DOC17/620154-02
SSD 8373

30 January 2018

**SSD 8373 – ALEXANDRIA PARK COMMUNITY SCHOOL – ENVIRONMENTAL IMPACT
STATEMENT (EIS)**

ALEXANDRIA PARK COMMUNITY SCHOOL

3
3002
DETAILED_Elevation 3
1 : 200

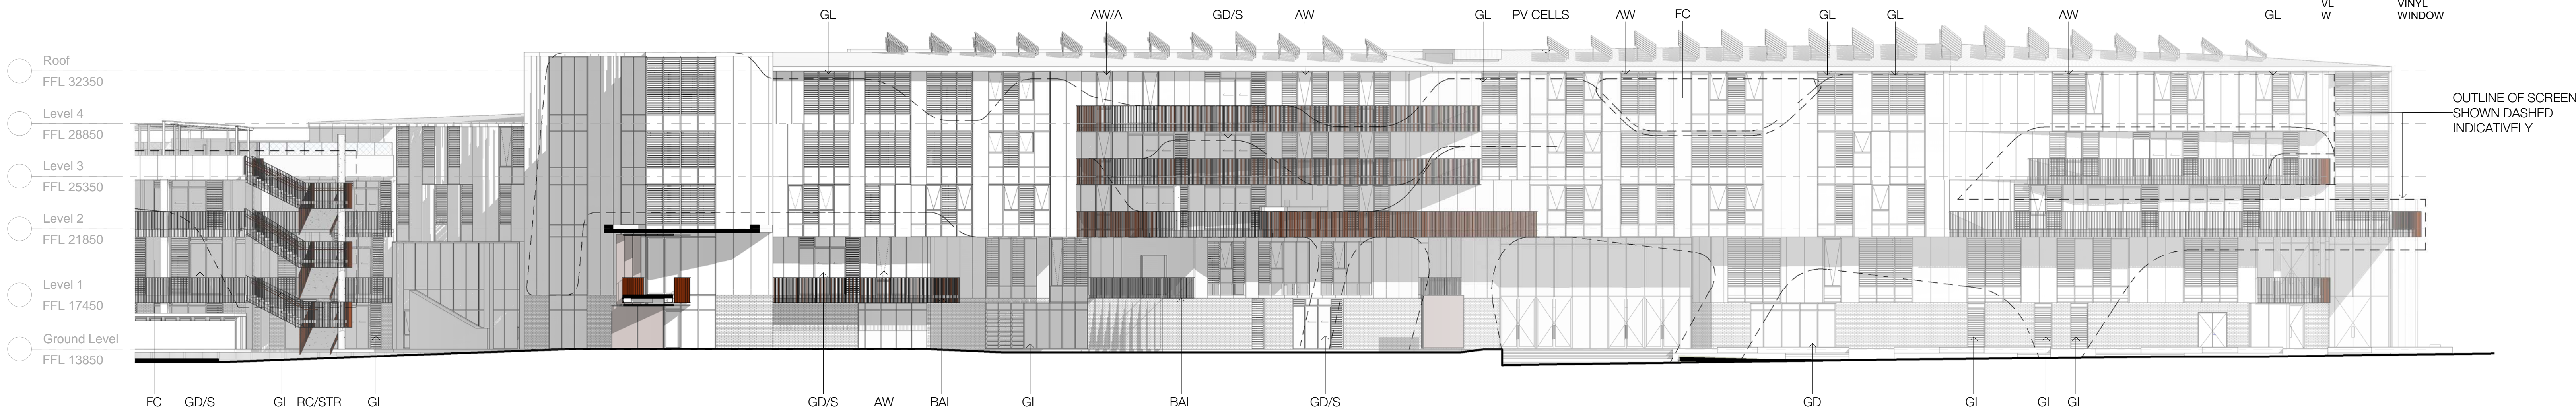
- (b) noise from music events held in the sports hall are expected to adversely impact residences during the 'evening period' (i.e. 6.00 pm to 10 pm) unless door openings on the northern elevation are closed.

The proponent be required to ensure the sports hall is not made available for community use –

- (i) between 10.00pm and 7.00 am week days and Saturdays, and
- (ii) during Sundays and public holidays.
